Application Ref:	2025/0937			 Ribble Valley Borough Council www.ribblevalley.gov.uk
Date Inspected:	N/A	Site Notice:	N/A	
Officer:	EP			
DELEGATED ITEM FILE REPORT:				APPROVAL

Development Description:	Certificate of Lawfulness for proposed rear dormers.
Site Address/Location:	Holly House, 8 Station Road, Rimington BB7 4DR.

SHEET: EXISTING SECTION AND
EAVES PLAN

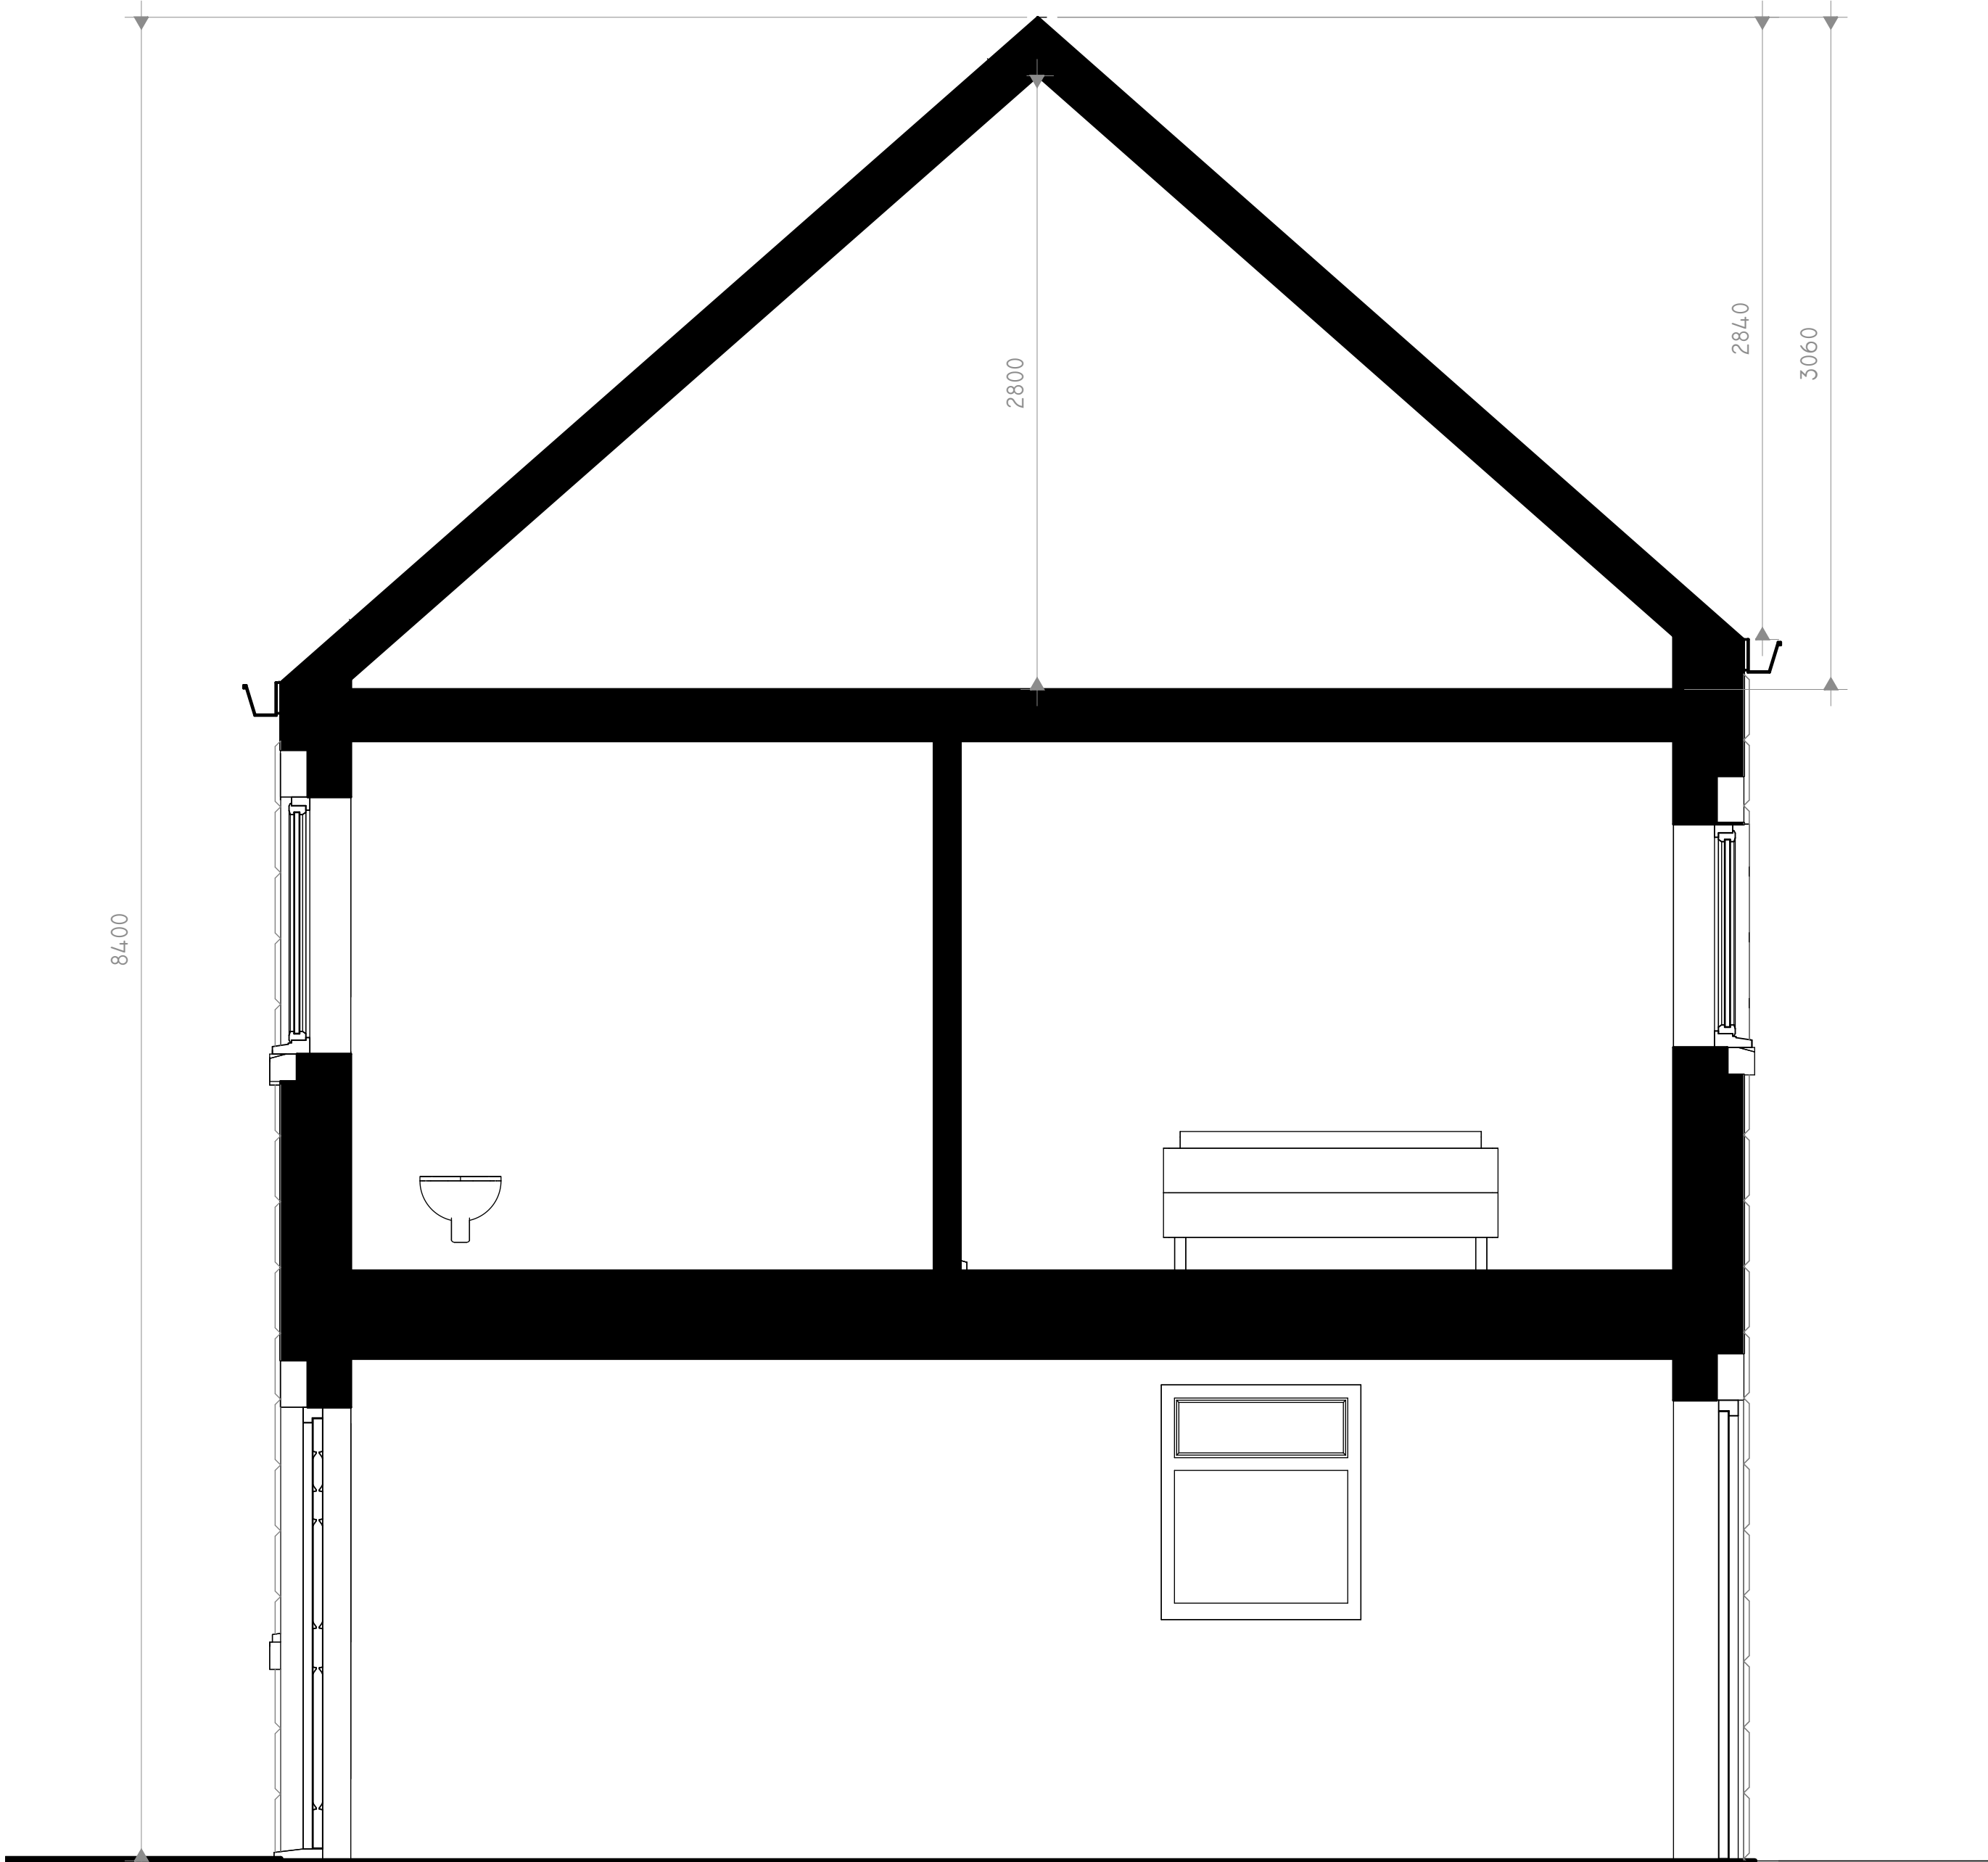
The existing dwelling has consent for a roof lift which increases the original roof volume by 18 cubic metres. The proposed dormer extensions will increase the original roof by a further 27 cubic metres. The overall increase is therefore 45 cubic metres and compliant with the above.
